In response to further information provided by the Agent (email including the latest revision (03) of their drawing no. DPA-01, Pope Stevens Architecture Ltd.) I conclude as follows:

NATIVE PLANTING
Hedging shown green on the plan to consist of a double row of the following native hedging bare root plants 40 – 60cm in height, planted in a random mix.

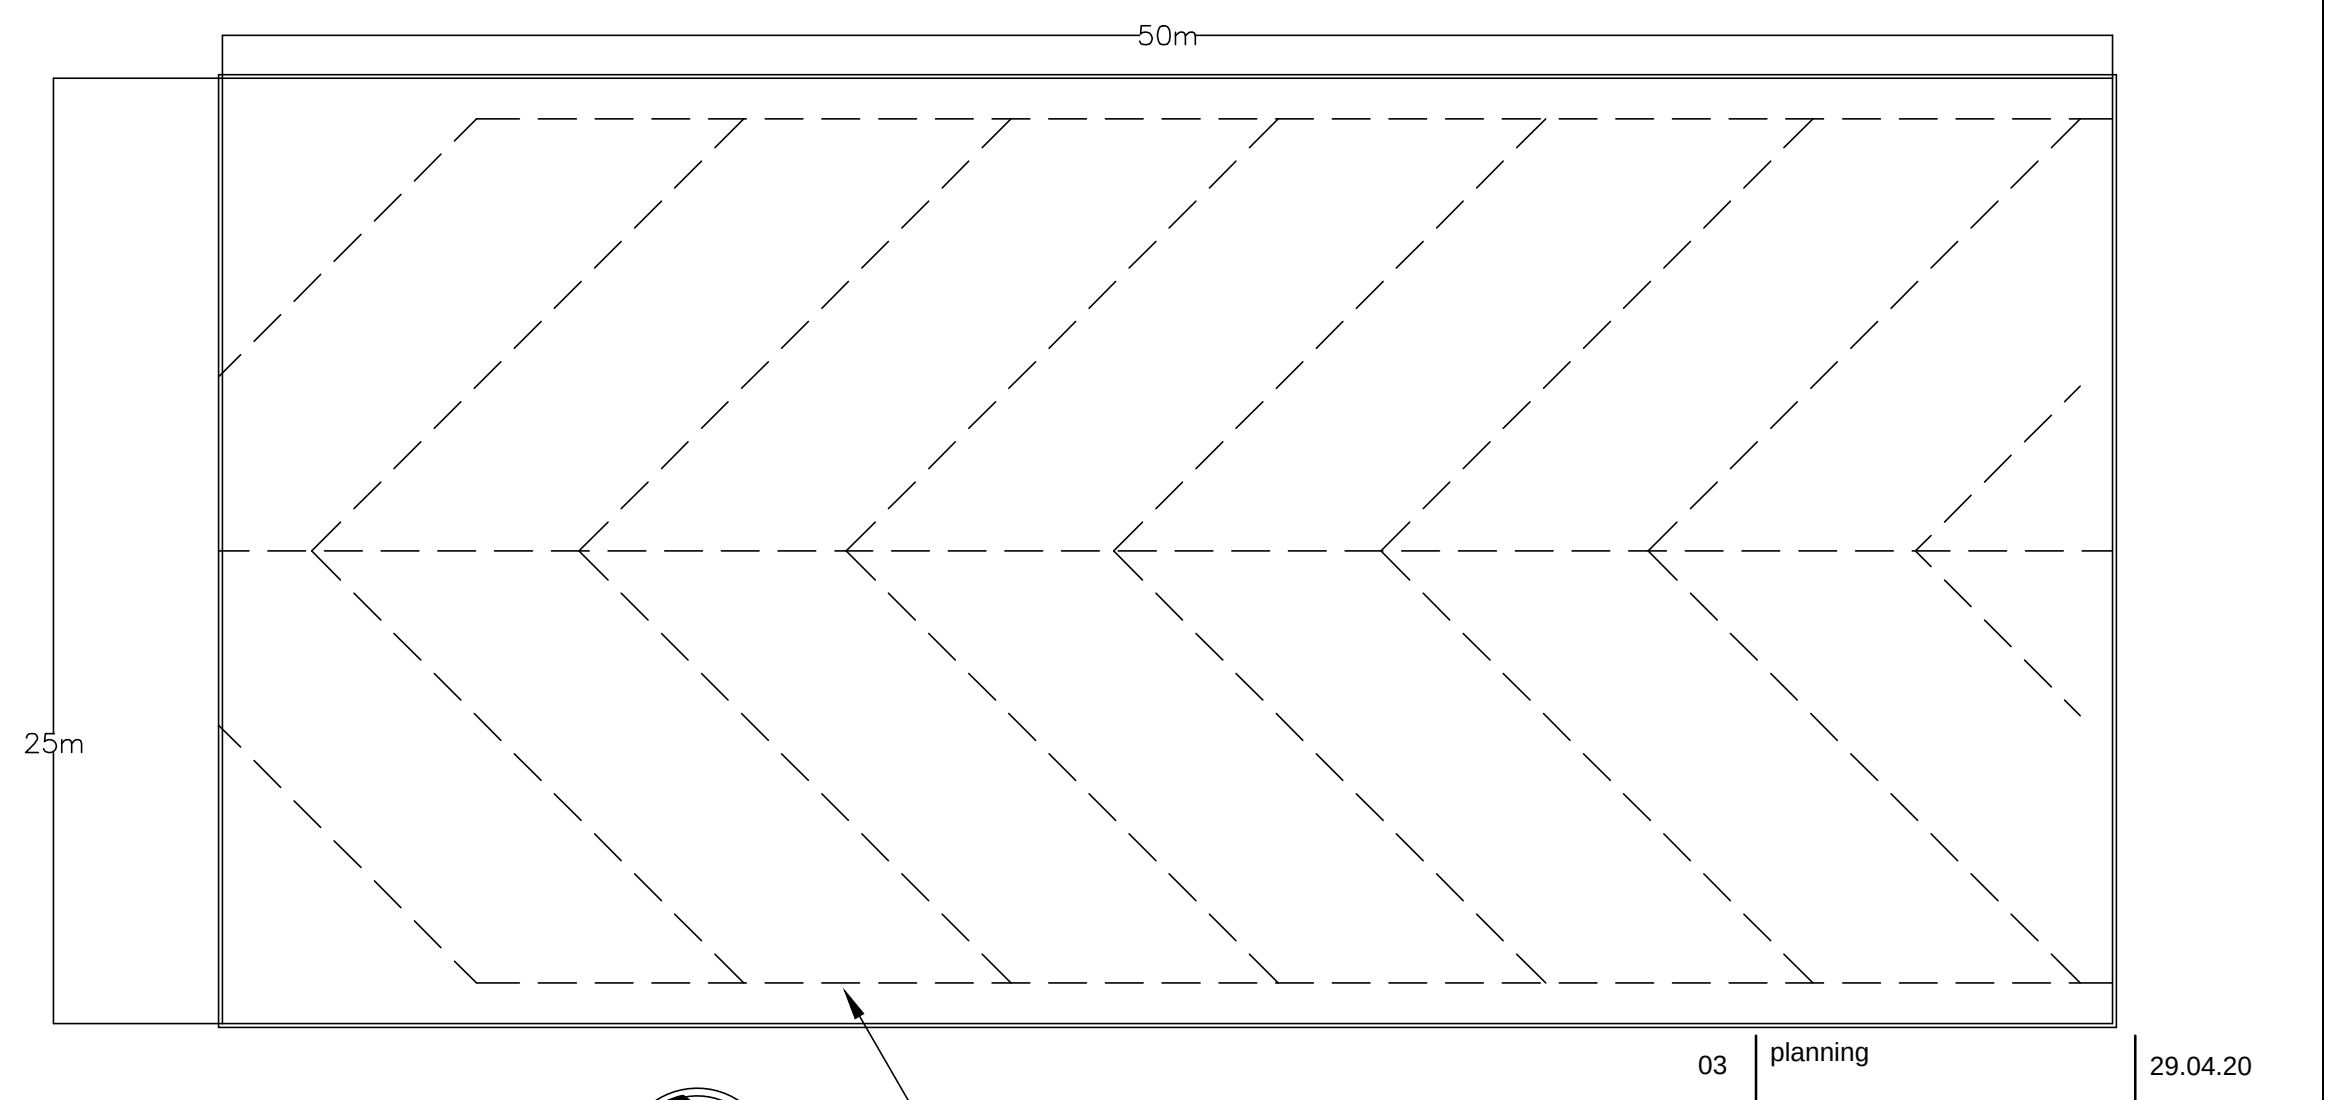
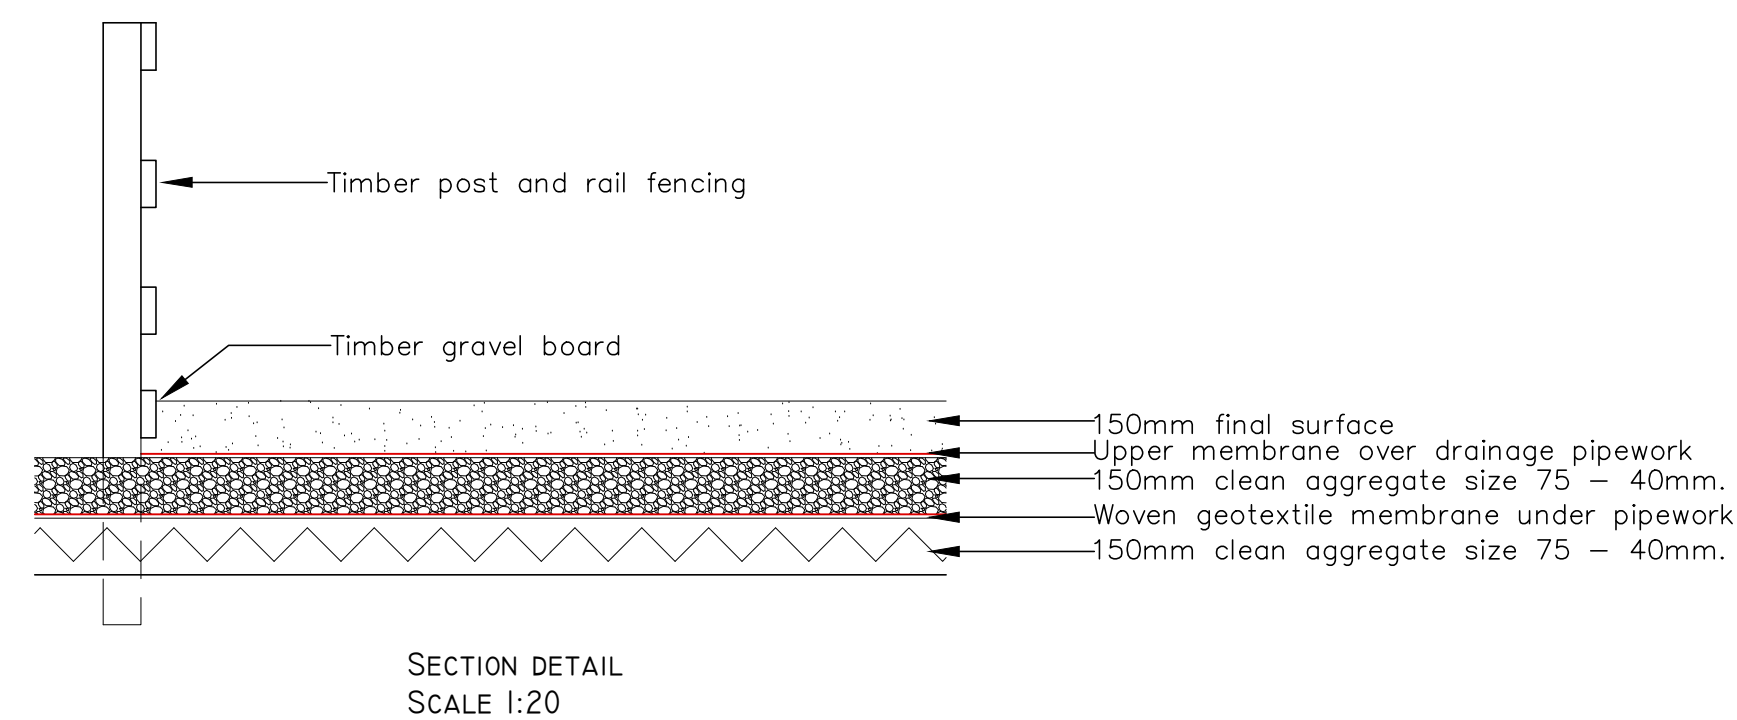
1. The Construction Management Plan describes the heavy plant to be used to deliver materials, single access route in/out of site and compound area for storage of materials. I am satisfied with this plan which should be included in a condition forming part of any APPROVAL.
2. Clarity has been provided around the extent of the native tree/hedgerow planting scheme. Although not as ambitious as first proposed, it nonetheless has the potential to adequately compensate for the removal of those trees around the polytunnels, if adequate aftercare is applied.
